From: [REDACTED]
Sent: 05 May 2026 16:03
To: Planning
Cc: Walsh, Kathryn
Subject: 3/2025/0997 Land off Henthorn Road Clitheroe BB7 3BY
Attachments: PRow Overlay.pdf

Reference 3/2025/0997
Location Land off Henthorn Road Clitheroe BB7 3BY
Proposal Outline application for the erection of up to 115 dwellings, including affordable housing, with public open space, landscaping, sustainable urban drainage system (SuDS) and vehicular access. All matters reserved except for means of access.

Lancashire County Council Public Rights of Way Team raises no objection to the application and provides the following.

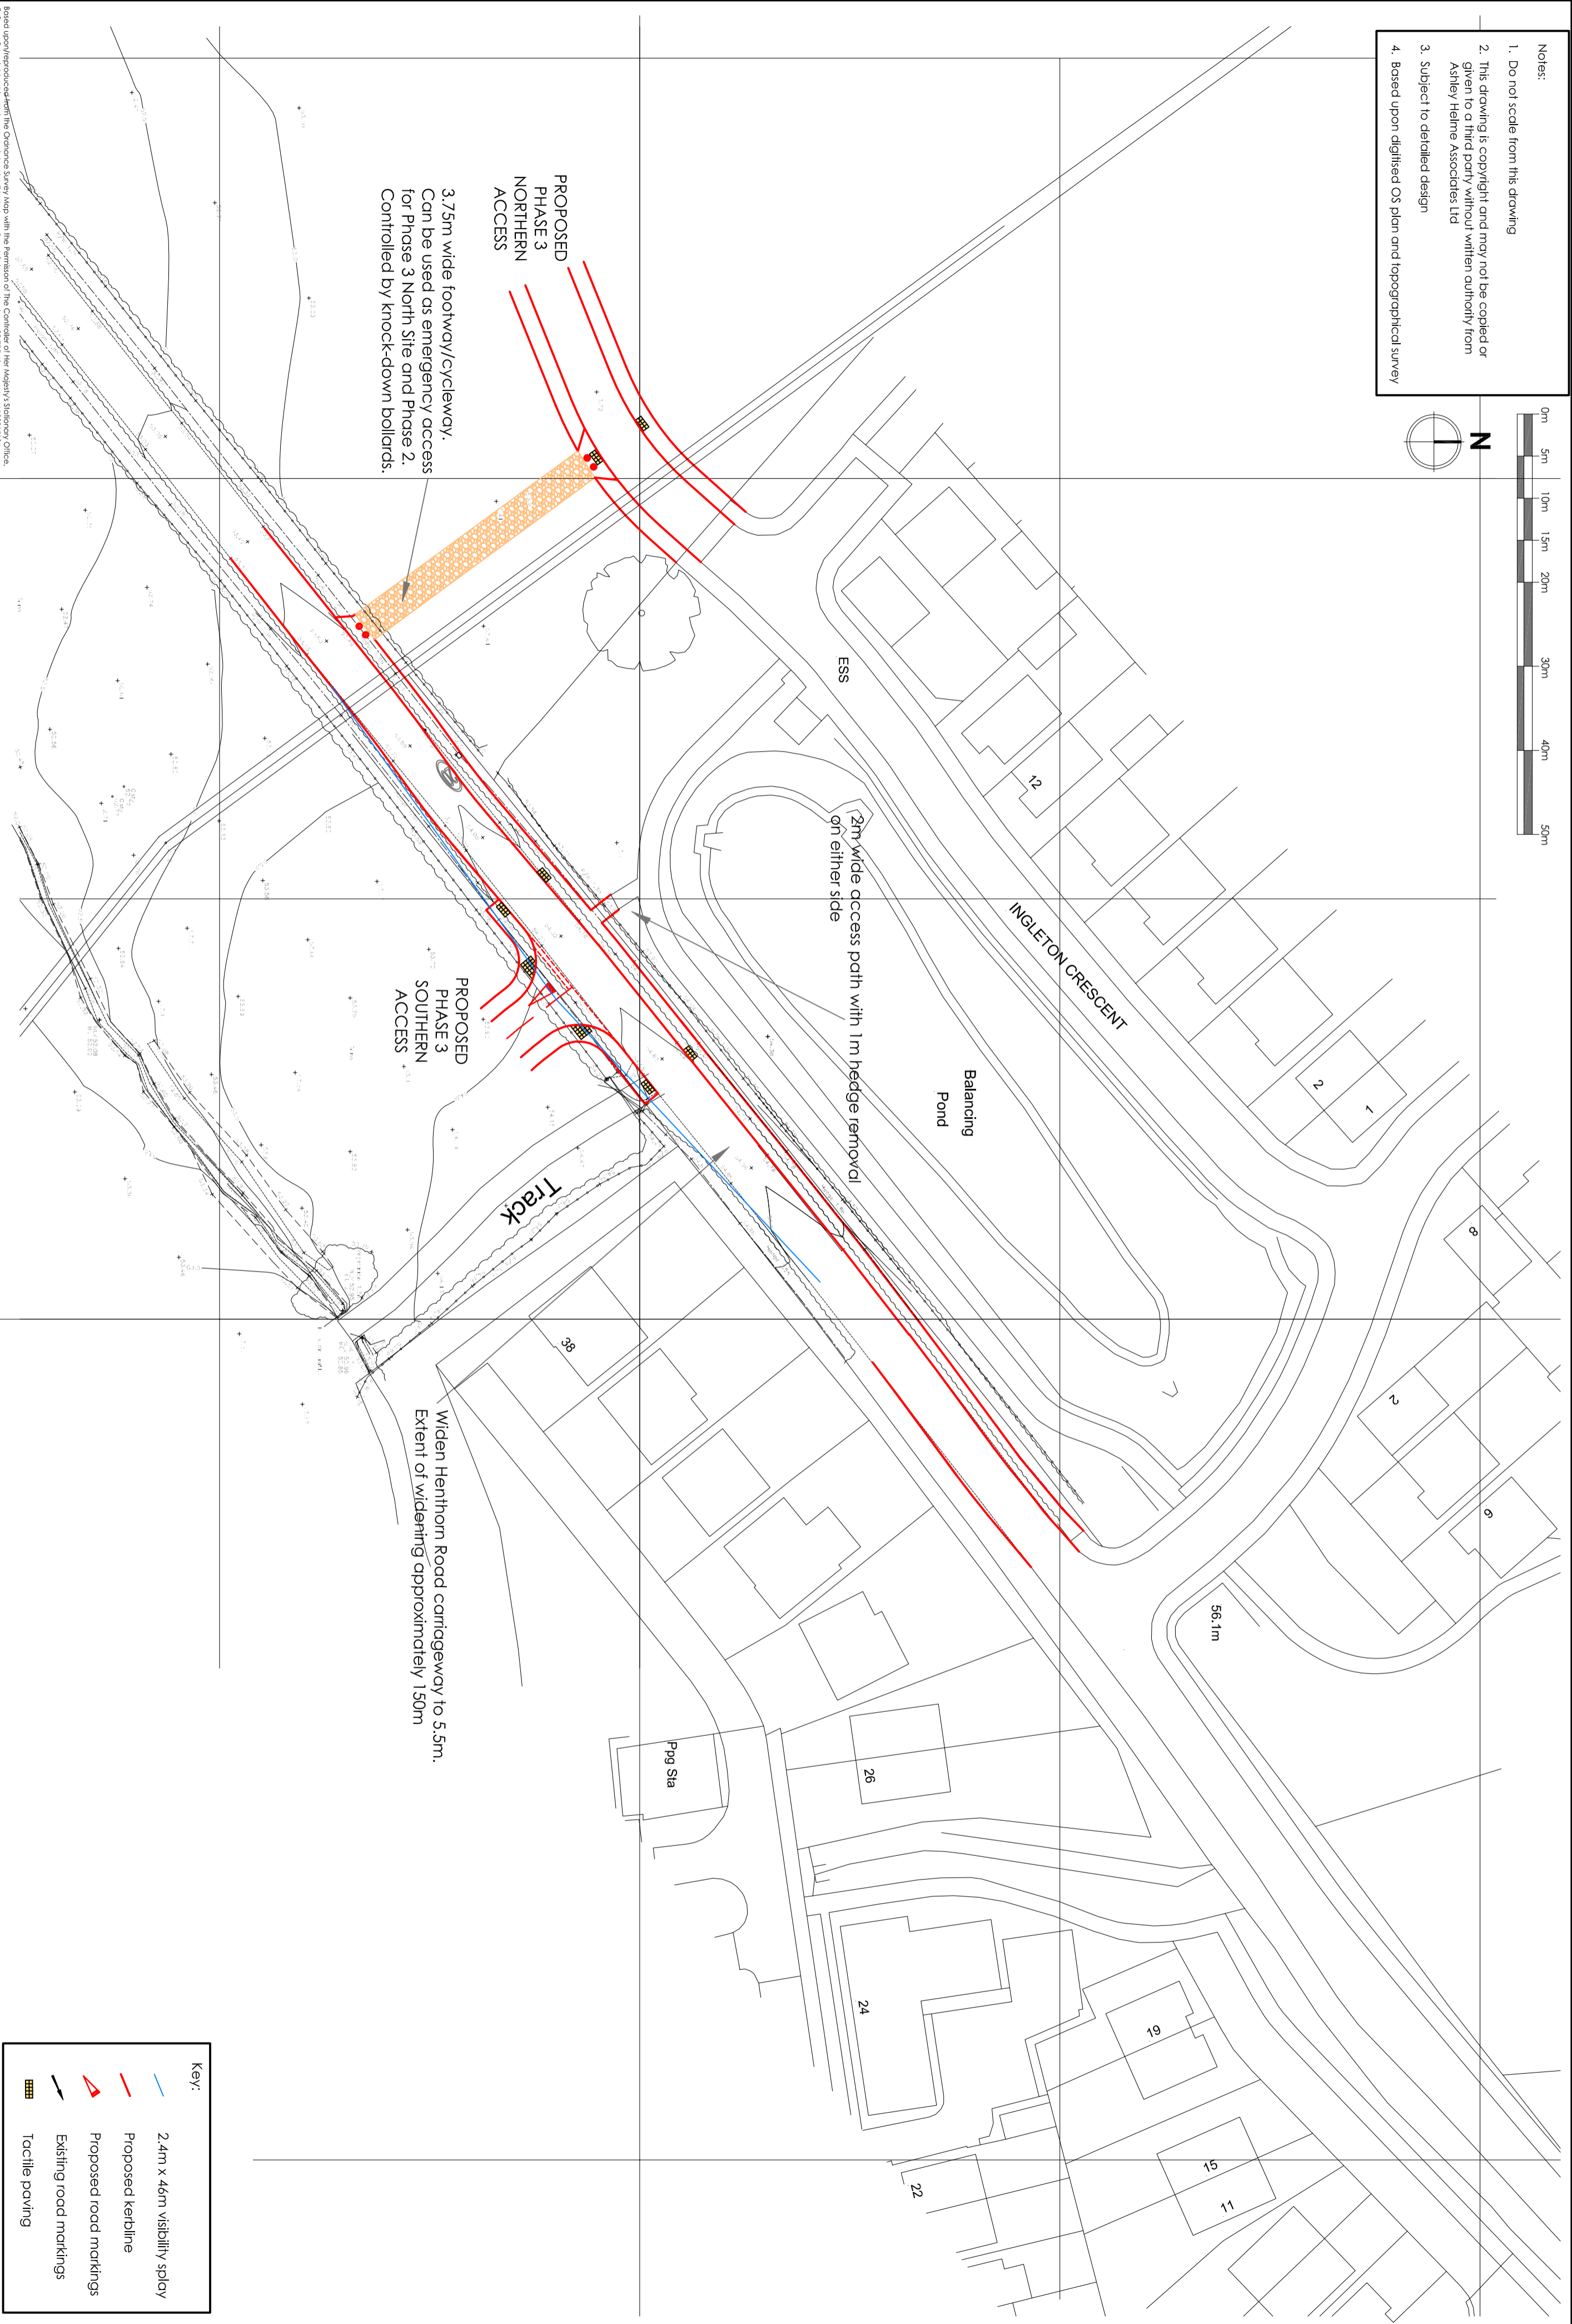
Footpath FP0301017 is recorded as running west to east through the proposed development connecting Edisford Road to Primrose Road via Henthorn Road, as indicated by the indicative line on the attached overlay. The National Planning Policy Framework 2024 places an obligation on developments to protect and enhance public rights of way and access, including taking opportunities to provide better facilities for users. The Public Rights of Way Team welcomes the definitive line of the footpath to be retained through open space away from vehicular traffic, avoiding the use of estate roads in line with Defra Rights of Way circular (1/09). However, it is of the view that the development would not meet the NPPF requirement without the inclusion of a new path connecting the dwellings to the right of way.

To improve connectivity and mitigate against additional footfall following the increased number of dwellings the new path from the development and the right of way is to be a minimum 3meter wide surfaced path. The detail of which is to be included within the S278 Agreement.

Prior to commencement of development, construction specification details for footpath FP0301017 and the connecting path shall be submitted to and approved in writing by Lancashire County Council's Public Rights of Way Team. The developer shall thereafter undertake the improvements in accordance with the approved specifications prior to occupancy of the first dwelling. The details shall include:

- Width, gradients and surface of the public rights of way and connecting path.
- location and details of any proposed infrastructure across the right of way.
- drainage methods to prevent the discharge or of water on the right of way.

- any planting to boarder the right of way.
- methodology to keep the disturbance and or closure of the rights of way to a minimum.
- No part of the development (in so far as it affects the public rights of way) can lawfully commence until a temporary footpath closure has been granted.
